From Robin Brown
Hayes Community Development Forum

Re: Planning Act 2008 (as amended) Section 88 and the Infrastructure
Planning (Examination Procedure) Rules 2010 (as amended)
Application by Highways England for an Order Granting Development Consent for the proposed M4
Junctions 3 to 12 Smart Motorway

For 'Deadline VI': Comments on submissions made for Deadline V, 8th January 2016 by Robin Brown
on behalf of the Hayes Community Development Forum
I refer to the Panel's Questions and the responses made.

Stops 1 to 4: Cranford and Harlington Area

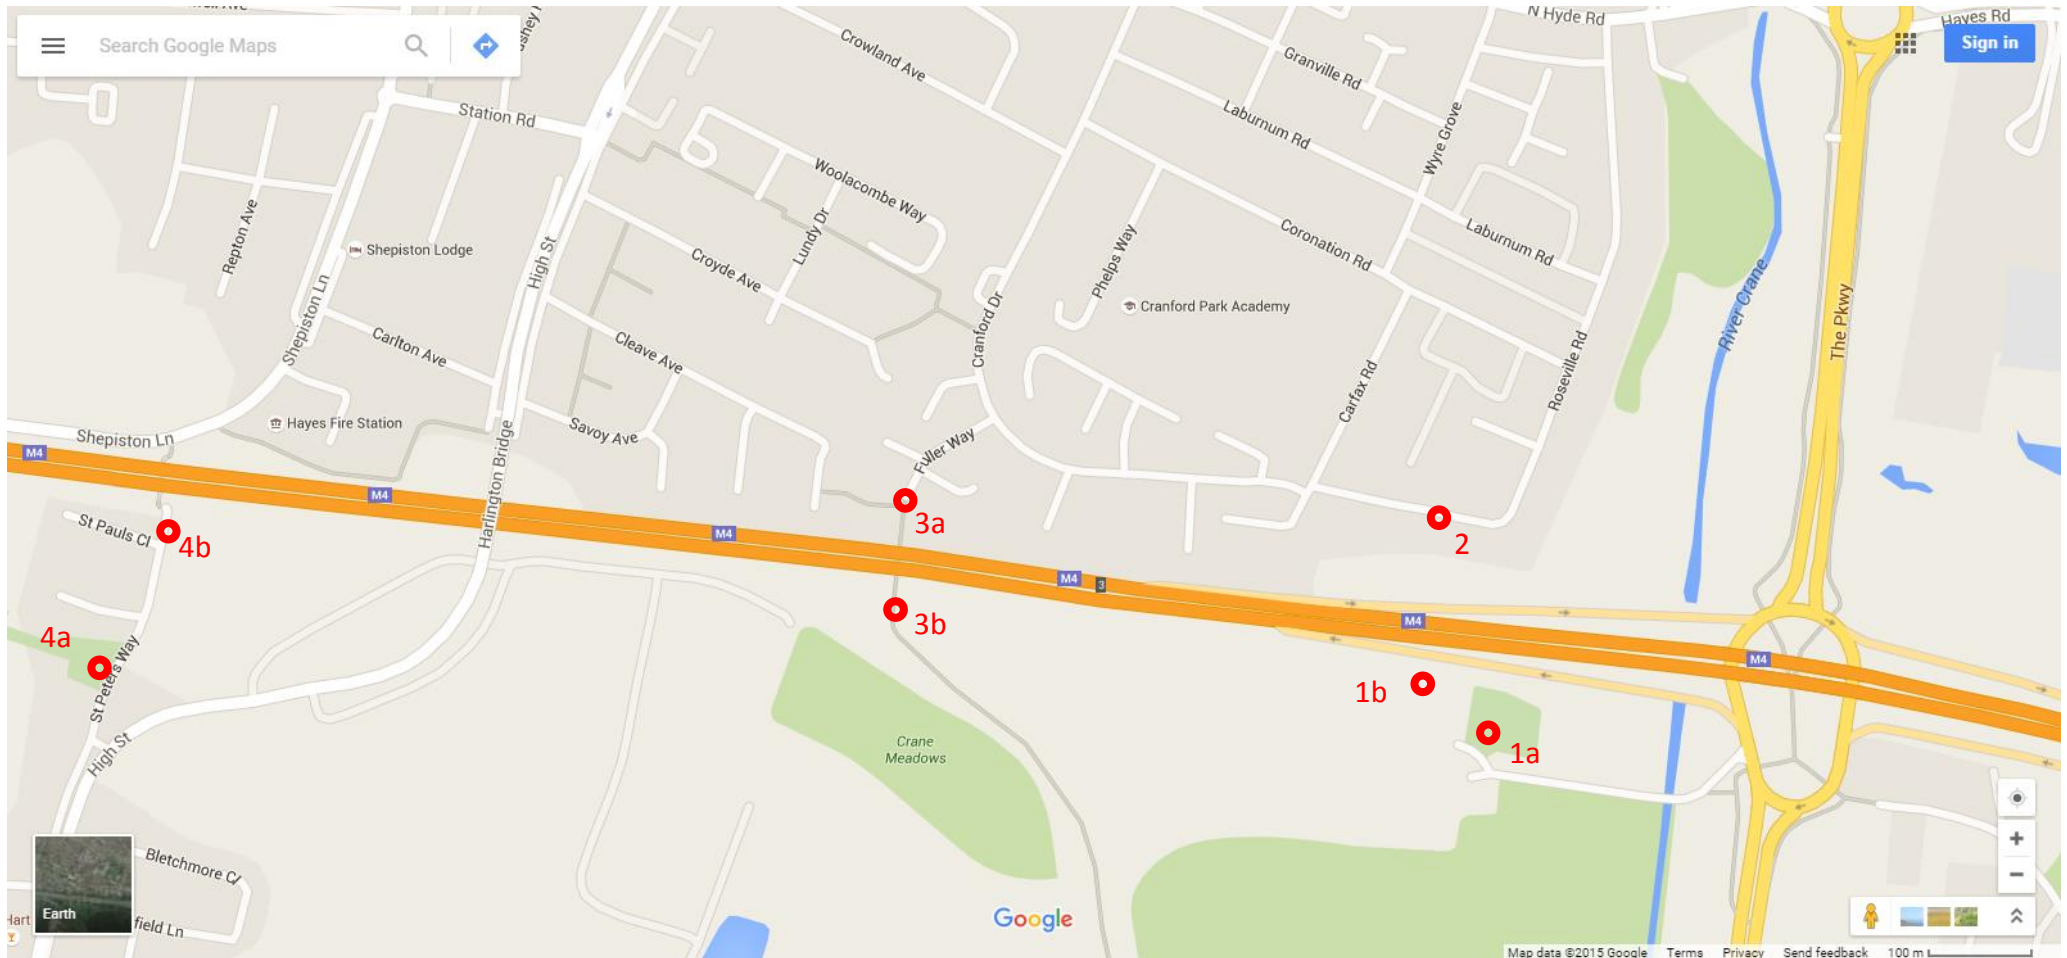
Great concern continues to be voiced at the lack of an effective acoustic and visual barrier alongside Cranford Park, particularly in the vicinity of the heritage assets.

Again, it is not understood why the proposed 3.5m high acoustic barrier (ref EM33) ends at the Park subway (circa 11220 chainage) and does not continue further east, albeit not necessarily at the same height. Previously it was assumed that there existed a circa 1.8m high acoustic barrier along the east bound carriageway and this informed the noise modelling. However, now a substantially higher barrier is proposed which seems to indicate that the noise climate from the scheme is predicted to be greater than could have been mitigated by the original 1.8m high barrier. If this is the case then the noise climate could be geographically more extensive and include homes in Cranford lying to the east of the Park's subway.

It is noted that additional barriers are recommended (ref EM34) and the Panel will be revisiting this location. This improvement will go some way to tackling the objections and concerns raised at the lack of mitigation in this area.
